A38 Derby Junctions

**8.27 Statement of Common Ground with
Little Eaton Parish Council**

Statement of Common Ground
Little Eaton Parish Council

Drawing Title  
FIGURE 2.7  
LITTLE EATON JUNCTION  
GENERAL ARRANGEMENT

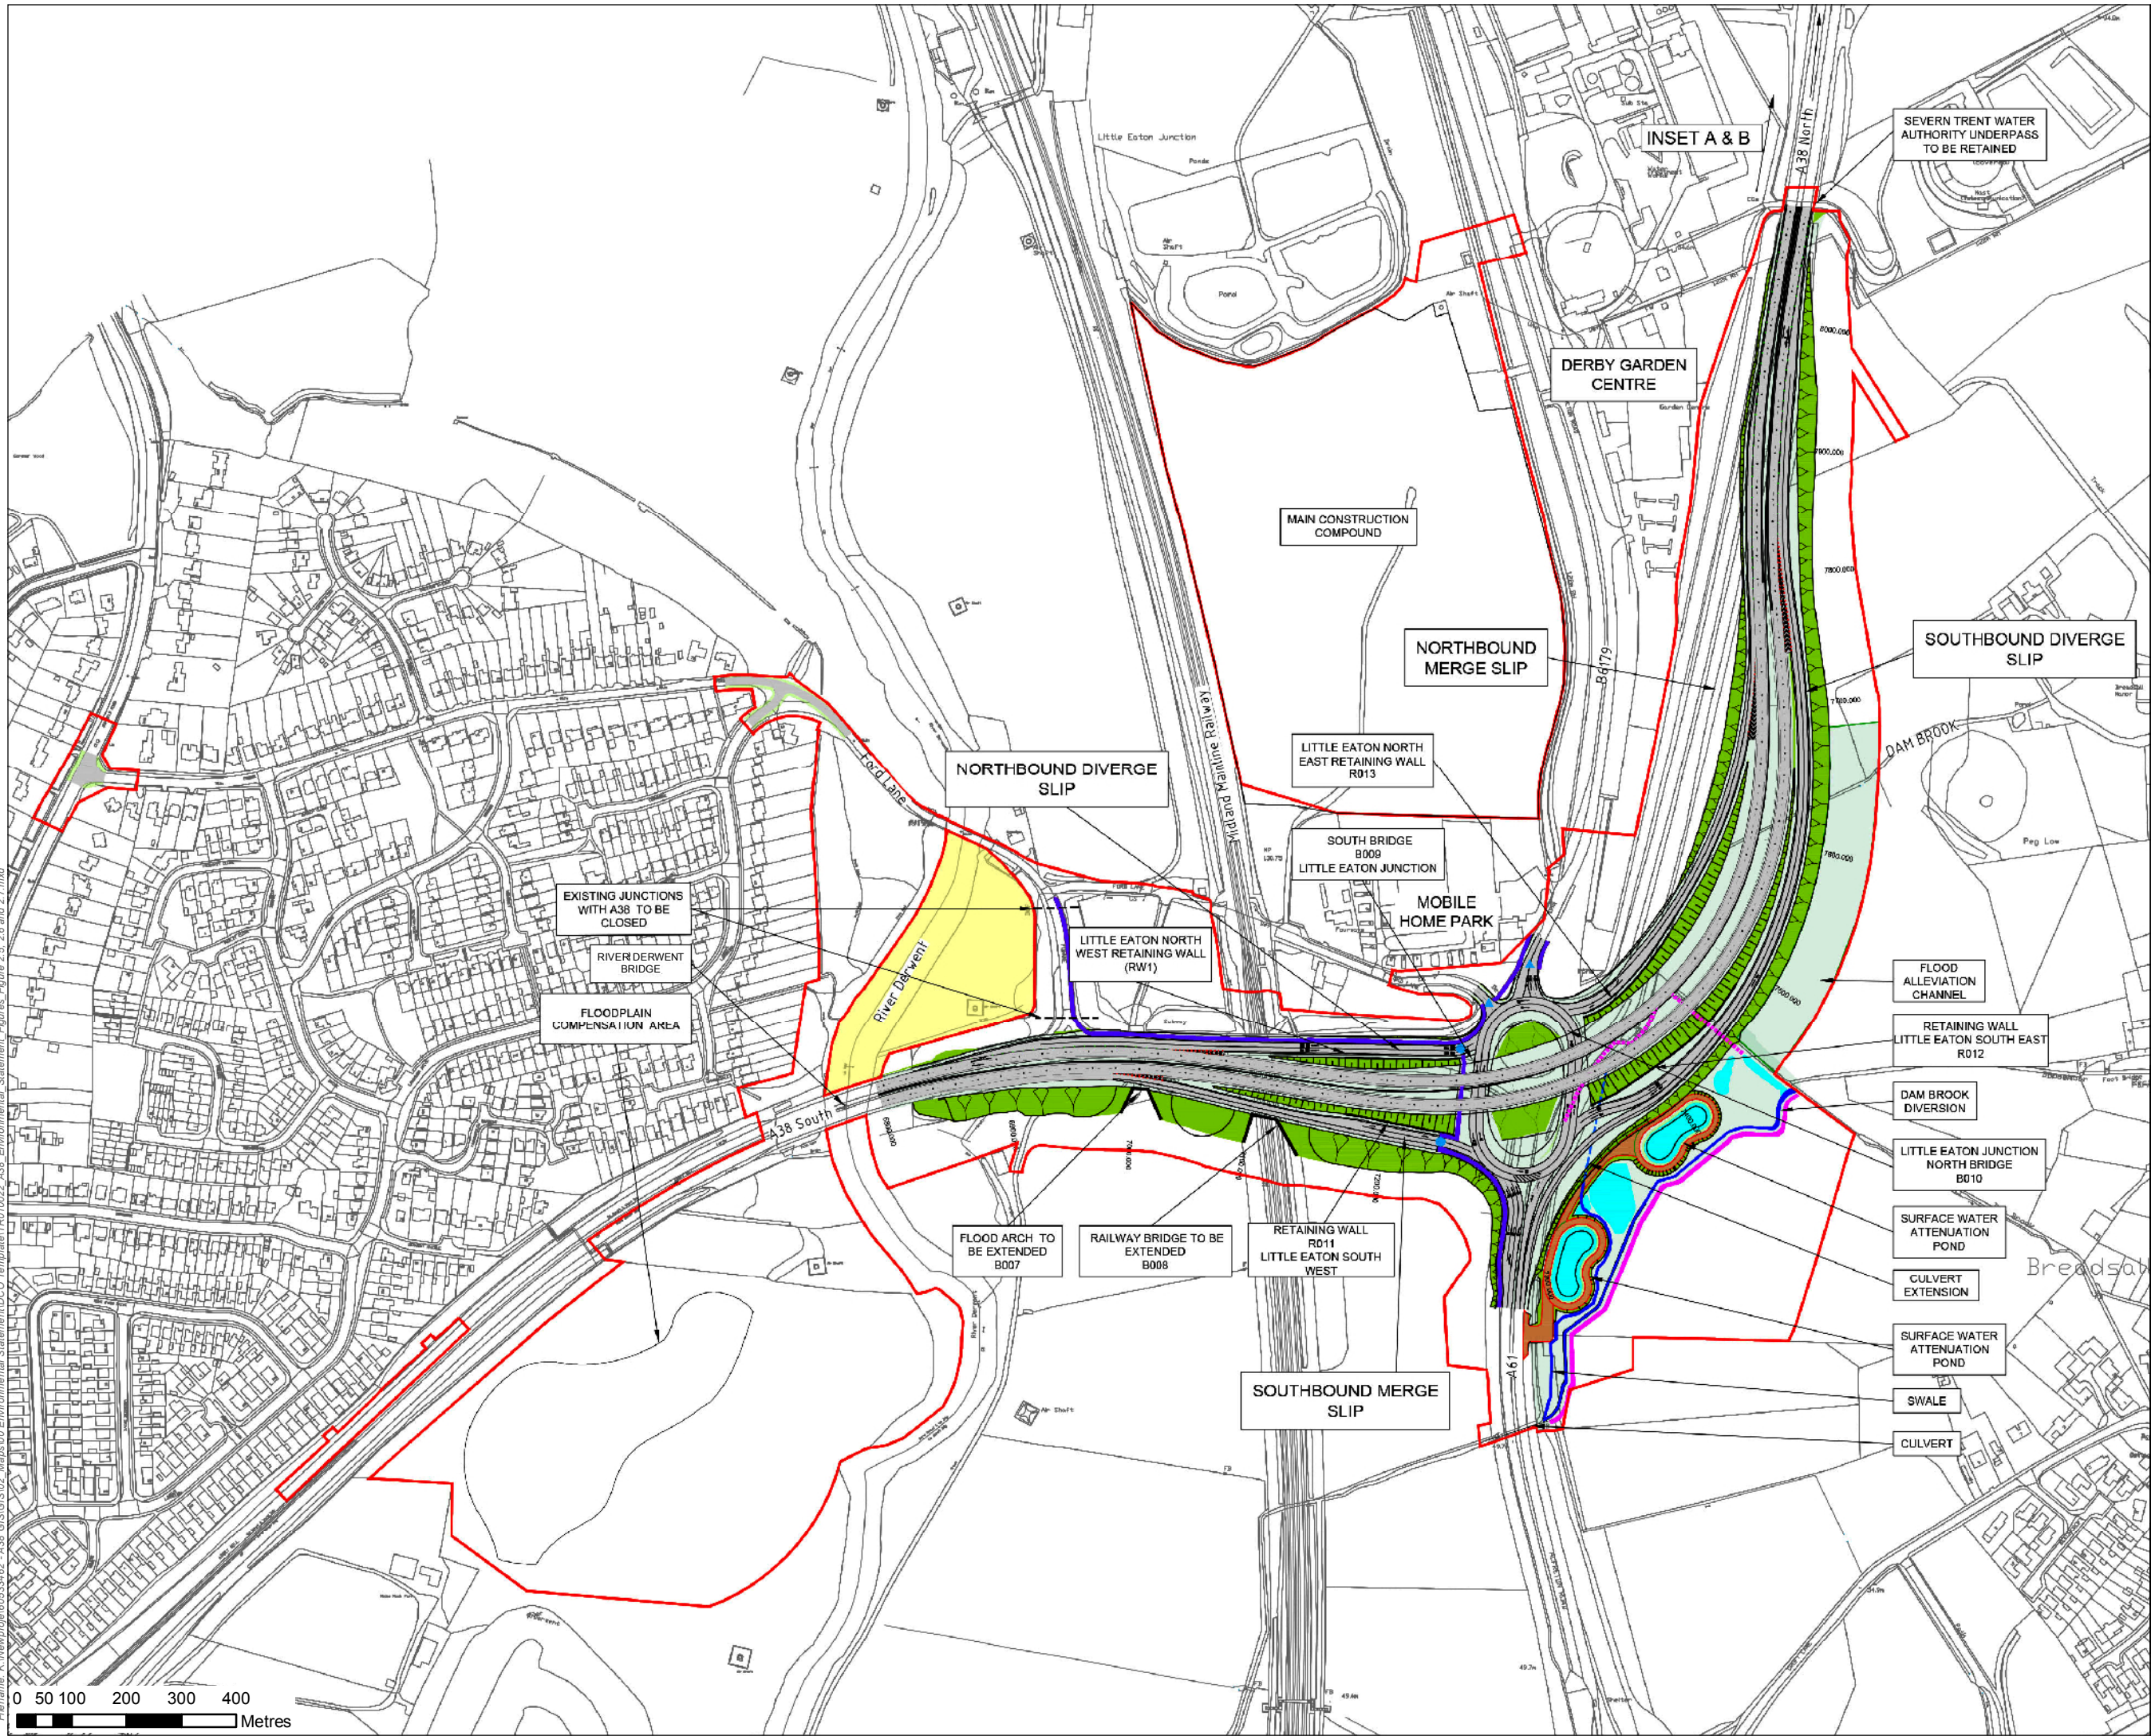
Document (if relevant)	Paragraph Ref (if relevant)	Sub-Section (if relevant)	Comment	Highways England Response	Status
Scheme alignment at Little Eaton junction	-	-	LEPC are in support of the Preferred Route as announced in January 2018 and were not in favour of any of the alternative options (as supported by the Breadsall Action Group - Option 3A, Southern Sweep, Option 2, Option X, Option X1 and Option 2C).	Highways England acknowledges LEPC's support for the preferred route at Little Eaton junction.	Agreed
Relevant Representation made by the Friends of Little Eaton Canal and endorsed by Little Eaton Parish Council*	-	a	The section that remains of the old Derby canal in Little Eaton is barely referred to in the PEIR. For example, there is no reference to the canal in sections 6.5.29 (The Derbyshire Historic Landscape Character) and 6.6.4 (Potential Cultural Heritage Impacts Identified During Preliminary Assessment). Nor in the Environmental Statement Chapter 6: Cultural Heritage [APP-044] published April 2019.	<p>The assessment presented in the Preliminary Environmental Information Report (PEIR) was updated and reported in the Environmental Statement (ES) as submitted with the DCO application. The former Derby Canal is referred to in several sections of the ES where relevant, whilst the ES also includes details as to how impacts upon the former canal would be avoided and minimised.</p> <p>ES Chapter 6: Cultural Heritage [APP-044] details the history of the former canal in Sections 6.8,</p>	Under discussion

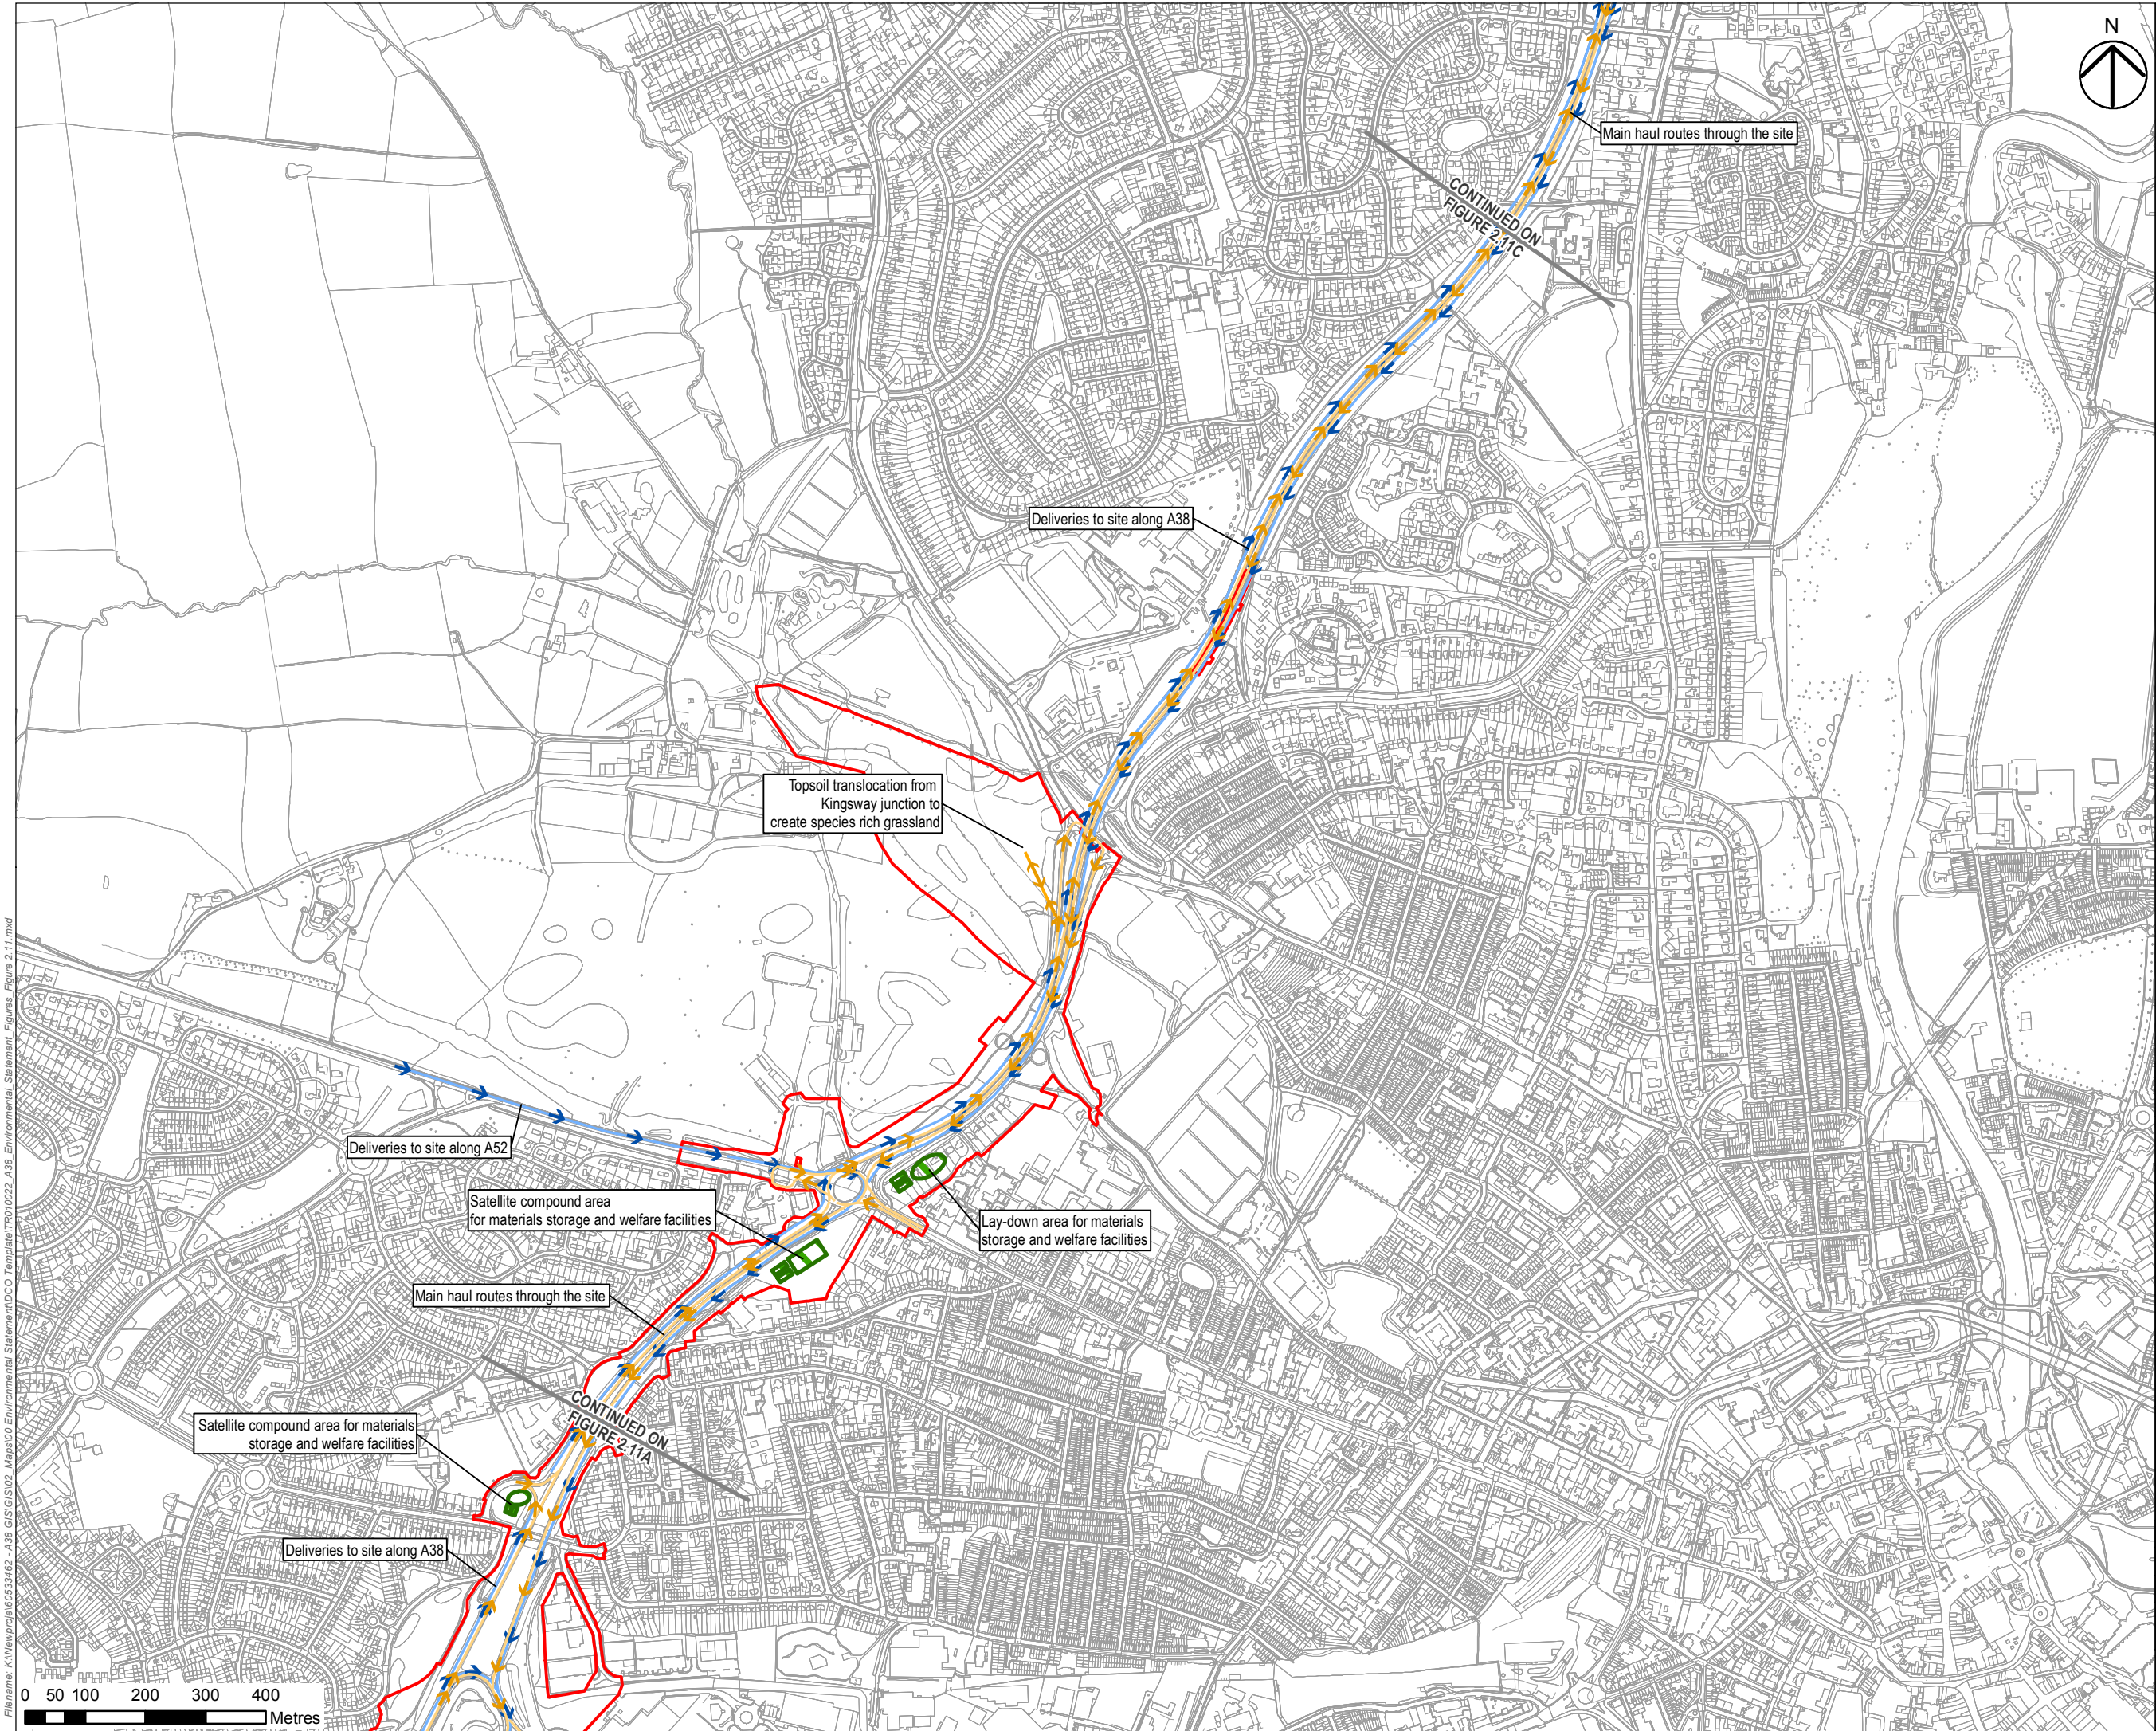
Document (if relevant)	Paragraph Ref (if relevant)	Sub-Section (if relevant)	Comment	Highways England Response	Status
				6.9, 6.10, and 6.11, whilst Section 6.14 details the actions to be taken to minimise effects upon the former canal, and Section 6.17 (Table 6.11) details the overall effects of the Scheme on the former canal.	
Relevant Representation made by the Friends of Little Eaton Canal and endorsed by Little Eaton Parish Council*	-	b	A clear boundary outline for the main construction compound does appear in Figure 5.3 Proposed Little Eaton Junction. But I believe it is an omission not to make reference to this area and the impacts the main construction compound site will have within the preliminary and subsequent PEIR documents. Although unaffected by the A38 upgrade itself, the potential site for the main construction compound – which requires access – will have a negative impact on the heritage and environmental aspects of the canal and its surrounding woodland, which is a green corridor stretching approximately a kilometre from the Little Eaton A38 Junction heading north to Duffield Road.	As detailed above, the ES assesses the Scheme impacts upon the former canal and details the measures that will be taken to avoid and mitigate potential impacts. As detailed in ES Chapter 6 Section 6.14 (see para 6.14.4) [APP-044] : <i>“The proposed access into the main construction compound at Little Eaton junction would need to cross over the remains of the former Derby Canal (Little Eaton branch). In order to avoid direct effects upon the former canal, a temporary bridge would to be used to cross the canal which would not require any disturbance or earthworks to the former canal.”</i> In order to install this temporary access over the former canal into	Under discussion

Document (if relevant)	Paragraph Ref (if relevant)	Sub-Section (if relevant)	Comment	Highways England Response	Status
				<p>the proposed compound, a strip of trees (approximately 8m wide) would need to be cleared. As detailed in ES Chapter 2: The Scheme, paragraph 2.6.104 [APP-040] “On completion of the works, the temporary bridge would be removed and the area appropriately restored”. As such, following removal of the temporary bridge system, the area of tree clearance would be replanted as native woodland planting.</p> <p>ES Chapter 6: Cultural Heritage [APP-044] reports that the Scheme effects upon the former canal would be slight adverse, and thus not significant. It is considered that the presence of the former canal has been taken into account, and the means of access into the proposed compound defined in a manner which would avoid direct effects upon it, whilst any tree removal would be reinstated when the access is removed.</p>

Relevant Representation made by the Friends of Little Eaton Canal	-	c	The canal, which still contains some of the original wall stones within its basin, dates back to 1796 and its continued existence	As detailed above, the Scheme will not have direct effects upon the former canal or any associated original structures at the crossing	Under discussion

Document (if relevant)	Paragraph Ref (if relevant)	Sub-Section (if relevant)	Comment	Highways England Response	Status
			intrusive by going through an established wide, green verge and green corridor that is the canal. It will also bring more traffic flow to that part of the village and will cross a multi-use footpath.	<p>Following completion of the Scheme, it will be a matter for the local planning authority to consider any future development proposals of the proposed compound site in accordance with relevant local planning policies. However, it is stressed that the access into the compound area will be removed at the end of the Scheme construction phase.</p> <p>In order to minimise traffic effects upon Little Eaton village, HGVs accessing the construction compound would be prohibited from accessing the site from the north (as detailed in the Outline Environmental Management Plan (OEMP) [APP-249] - refer to MW-TRA2 in Table 3.2b).</p> <p>The footpath along Alfreton Road which crosses the access into the proposed compound would remain open during the construction phase, with appropriate health and safety controls at the crossing point.</p>

Relevant Representation made by the Friends	-	e	Furthermore, the area needed to site the main construction compound uses greenbelt land	The proposed construction compound has been subject to a range of ecological surveys as	Under discussion

Document (if relevant)	Paragraph Ref (if relevant)	Sub-Section (if relevant)	Comment	Highways England Response	Status
of Little Eaton Canal and endorsed by Little Eaton Parish Council*			which is incredibly biodiverse and will be negatively impacted for years to come, again due to traffic movement to and from the depot and the siting of significant, albeit temporary buildings for staff and goods.	detailed in ES Chapter 8: Biodiversity [APP-046]. The layout of the compound has been defined taking advice from the ecology team in order to minimise the loss of species-rich grassland, retain areas scrub and trees, and retain a buffer of vegetation around the site to enable continued foraging and commuting by badger. Following completion of the works, the areas affected by the compound will be appropriately restored - restoration details are provided in the applicable the Environmental Masterplan ES Figure 2.12G [APP-068]. The ecological effects of using the compound area are detailed in the ES Chapter 8: Biodiversity [APP-046], taking account of the proposals to appropriately reinstate and replant the site.
